Cherokee Metro District

RE: *Solace Apartments Filing No. 2 – Utility Plans*

**SOLACE APARTMENTS FILING NO. 2**  
 SANITARY AND WATER SERVICE PLANS  
 SANITARY SERVICE PLAN

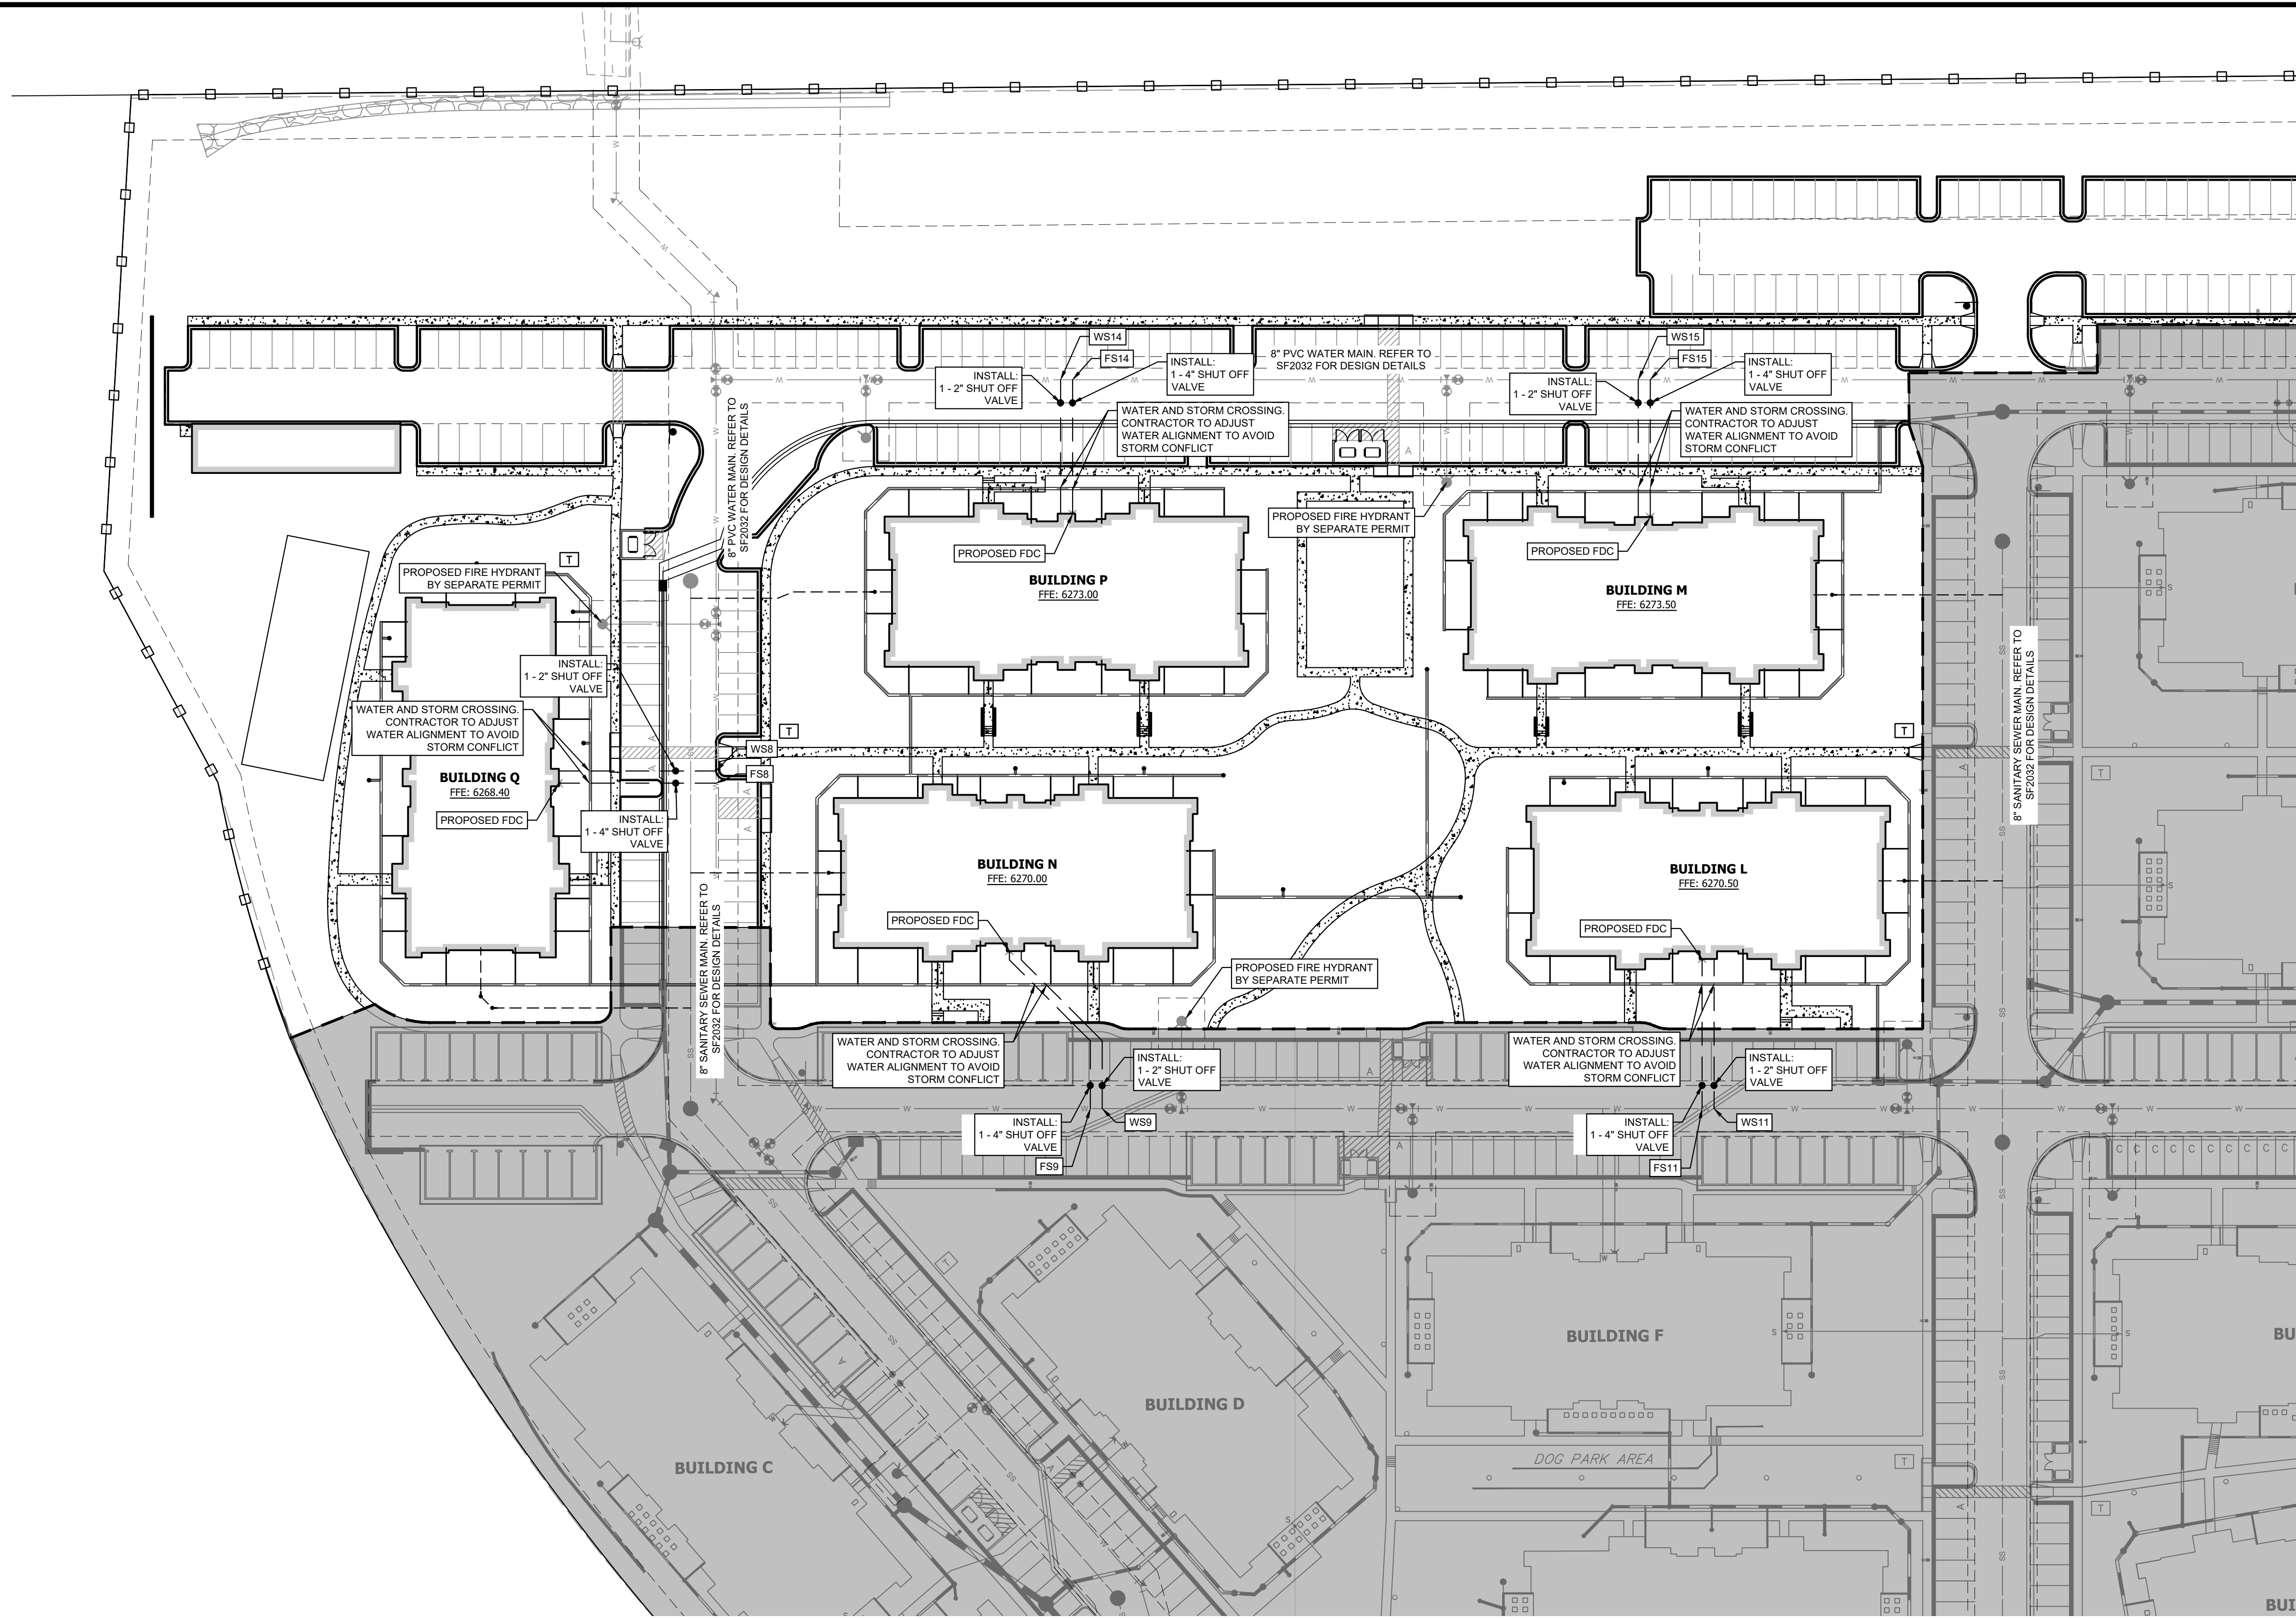
1. Wastewater and storm sewer lines must have a minimum separation of 18" (CSU Wastewater LESS Table 2-3). Proposed separations in crossings B and C do not meet this clearance. A casing pipe conforming to CSU standard detail 2-4 is required for these crossings.
 - *Response: The crossing casing has been added to each crossing that is under 18". The detail information is on the plans and noted in the crossing tables.*
